**Recommendation:** Refuse

**Proposal:** Certificate of Lawfulness of Proposed Development for a thermally efficient, low energy dwelling that suits the owner's needs without needing to build a carbon costly extension. The proposed works subtly update the exterior of the building whilst ensuring that it is still in keeping with the surrounding buildings

Alterations and updates to the exterior of the dwelling in accordance with drawing numbers 251\_05\_300 Rev P1, 251\_05\_301 Rev P1, 251\_03\_300 Rev P3, 251\_03\_150 Rev P3 and application form

Birch Hill, Burdrop, OX15 5RQ

<p>project Birch Hill, Burdrop, Banbury, Oxfordshire OX15 5RQ</p>	<p>drwg no 251_05_300 rev P1 title Proposed elevations (1) scale 1:100 @ A3</p>
---	---

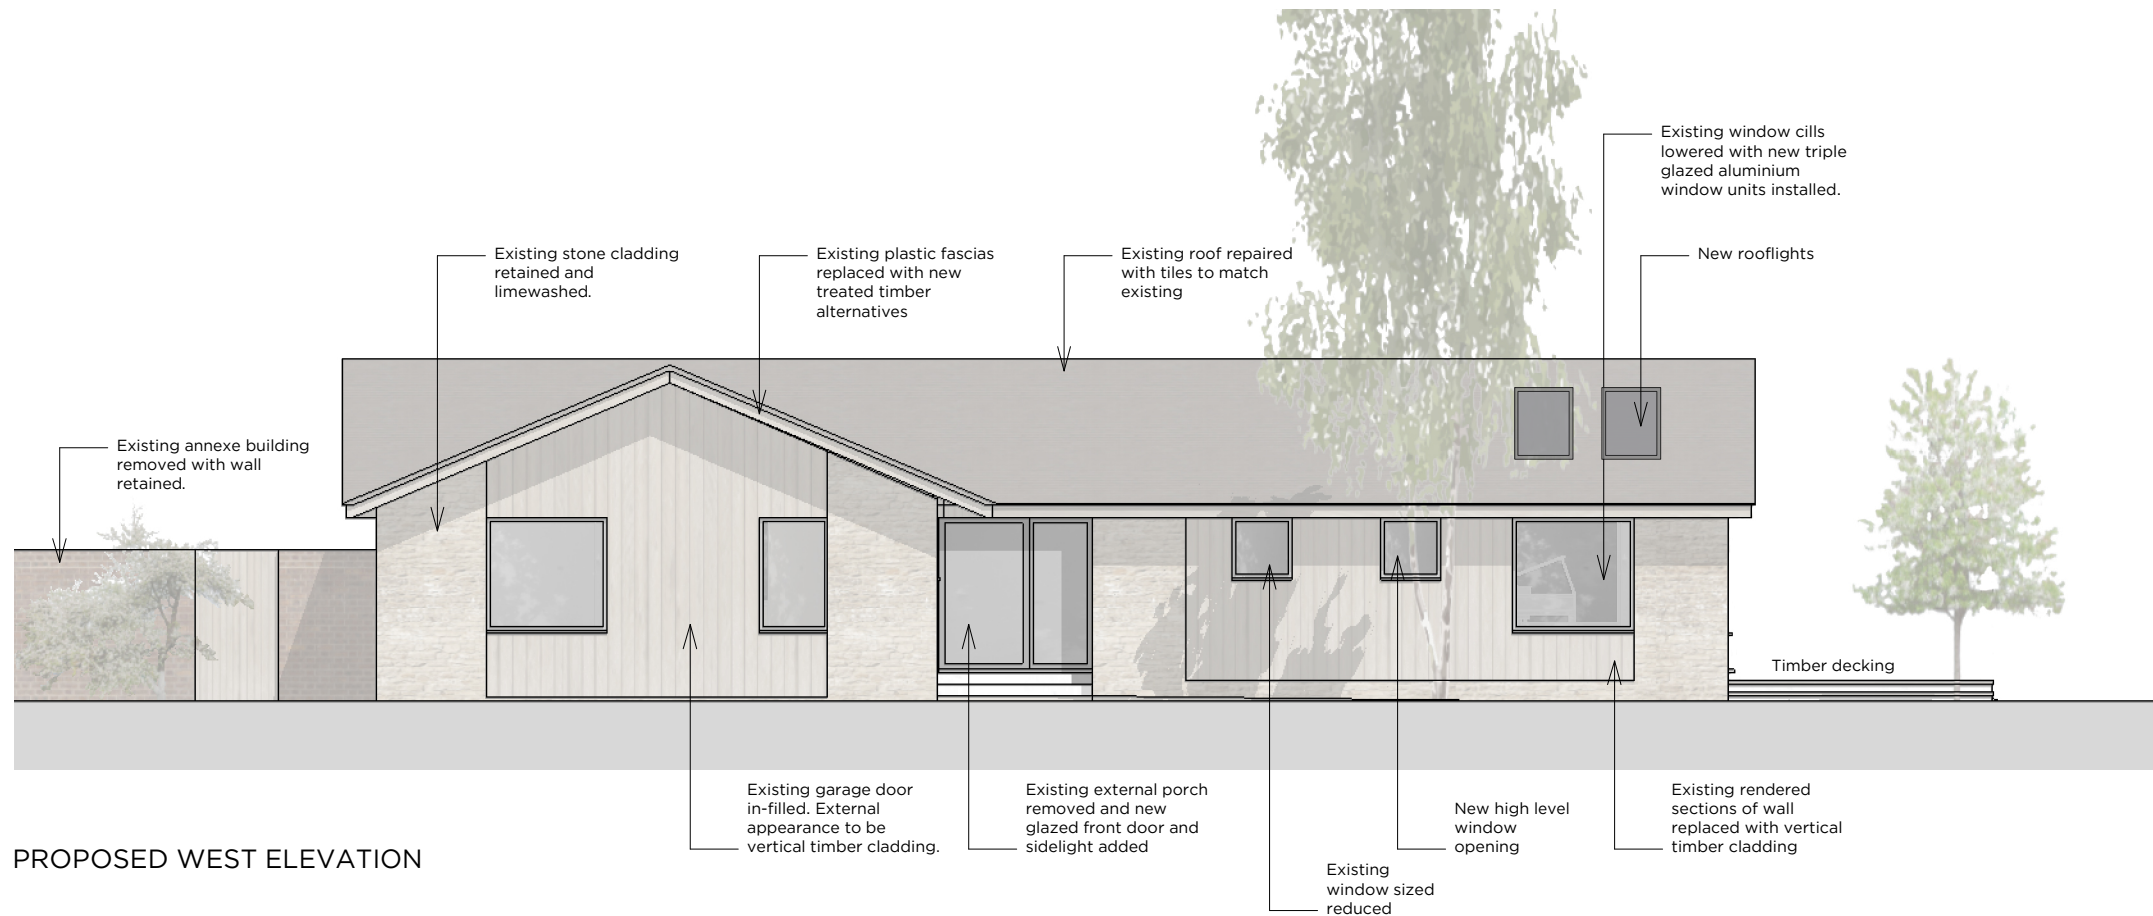
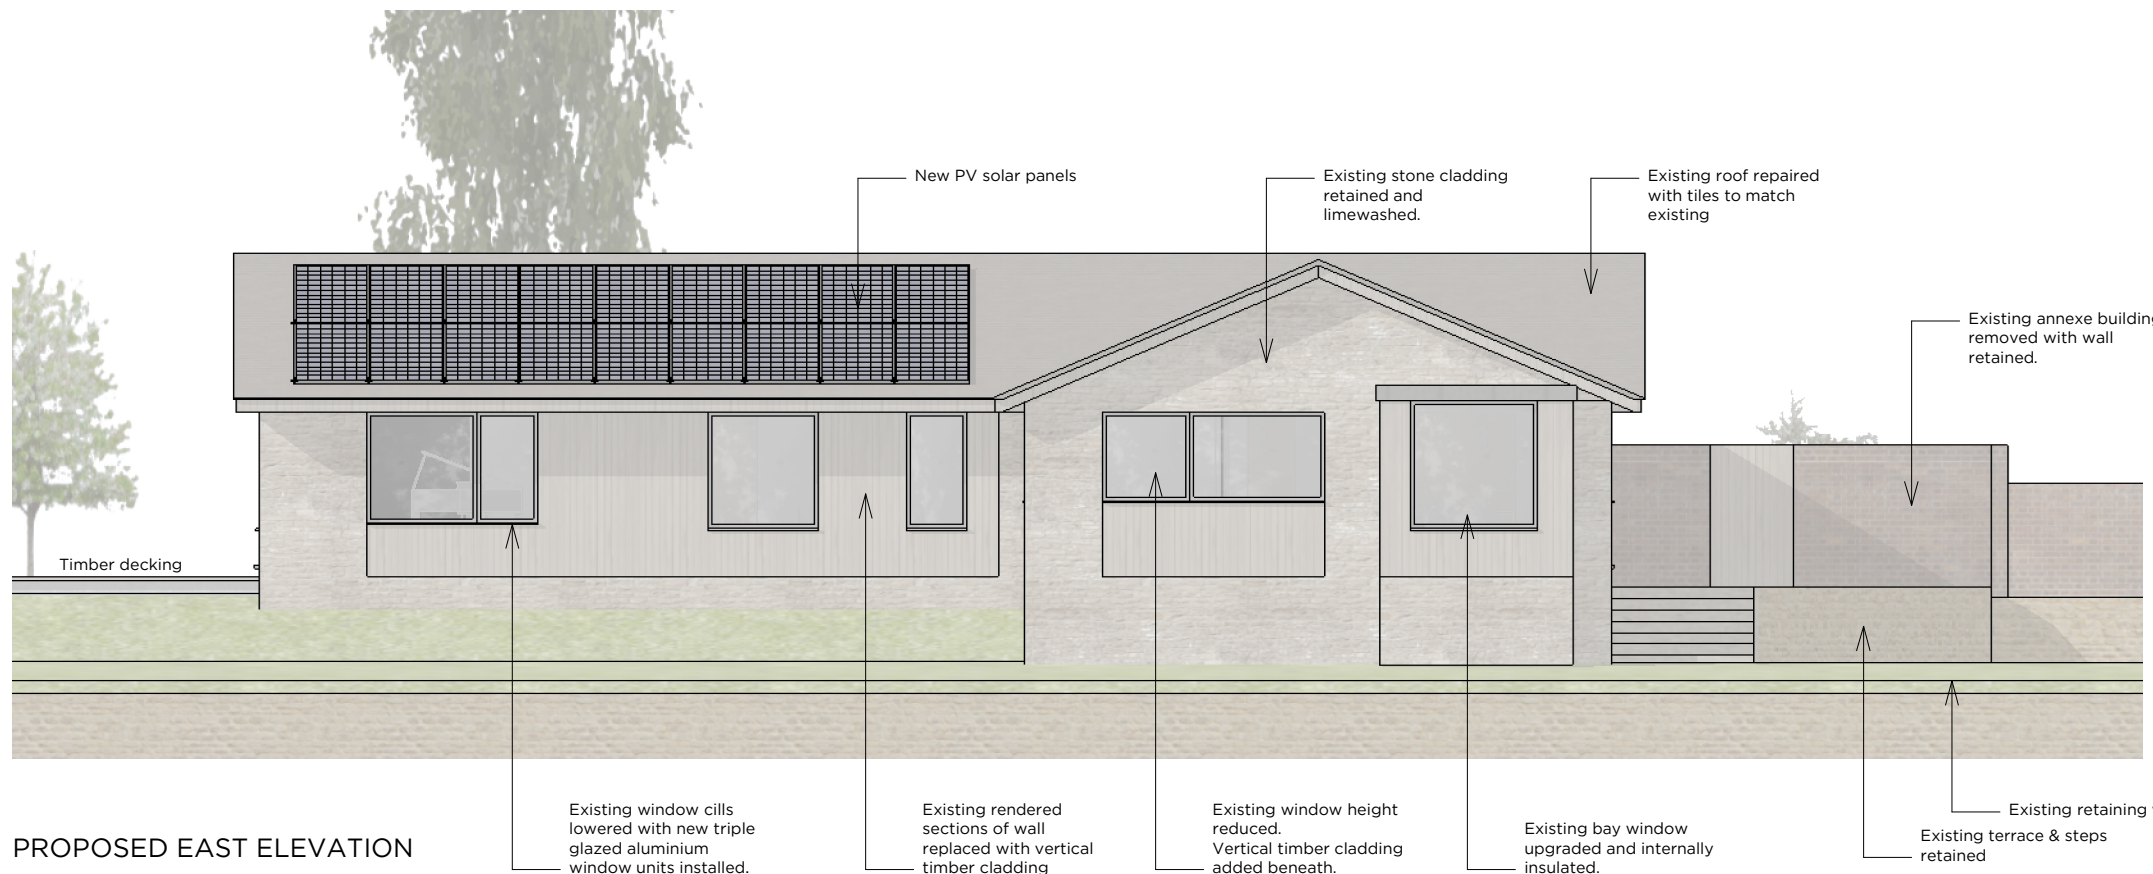
8.5. The construction materials; specifically the proposed vertical timber cladding to the front and rear elevations would not match those existing at the dwelling currently and would not match the materials within the locality and as such does not conform to the conditions set out in Schedule 2, Part 1, Class A of the GPDO 2015.

- 9.1. The materials proposed in association with the development; specifically the proposed vertical timber cladding to the front and rear elevations would not match those existing at the dwelling currently and would not match the materials within the locality and as such does not conform to the conditions set out in Schedule 2, Part 1, Class A of the GPDO 2015.
